Mr. Robert Greenlaw, P.L.S.
Back Bay Boundary, Inc.
65 Newbury Street
Portland, ME 04101

Subject: 101 Rowe Avenue
(ID # 2003-0185) (CBL# 261B022)

Thank you for your application for a single family at 101 Rowe Avenue. Upon review of the plan, it appears that this design would constitute a subdivision.

9/10/03

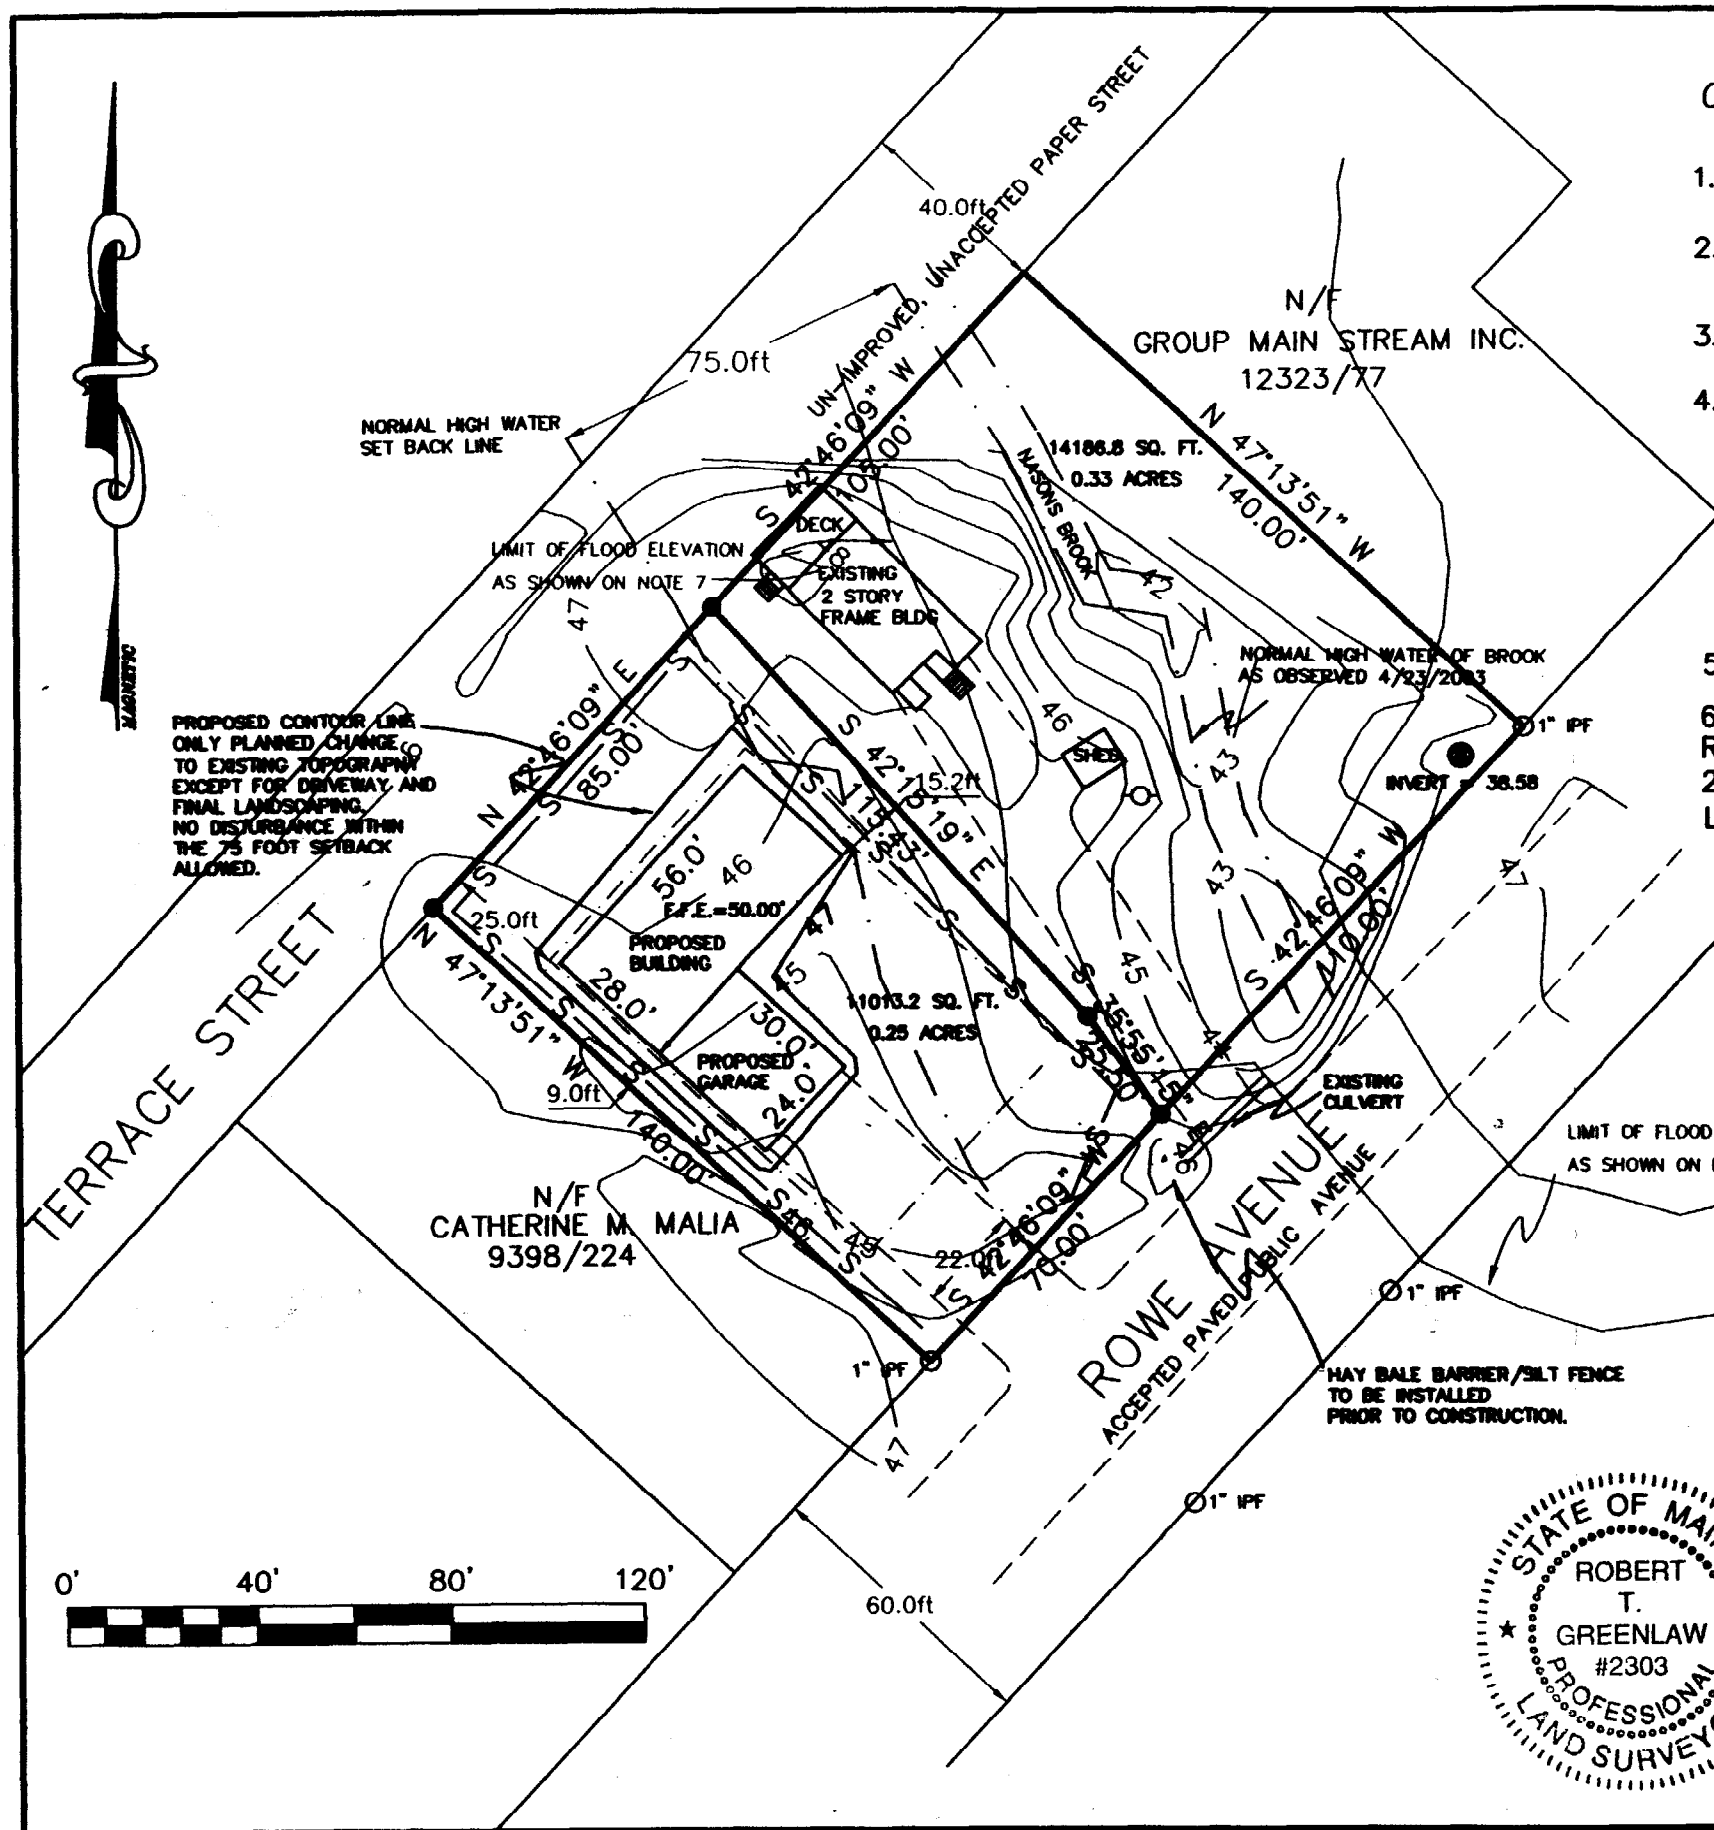
1. Please show all proposed topography (it appears incomplete in the front of the building).
2. The site appears to be within a stream protection zone. Please add the limits of the zone to the site plan.
3. Please add erosion control measures to the site plan.
4. One of the boundary line distances on the adjacent property is incorrect (either 105.00' or 110.00').
5. Please add the required street trees along the street frontage of the property.
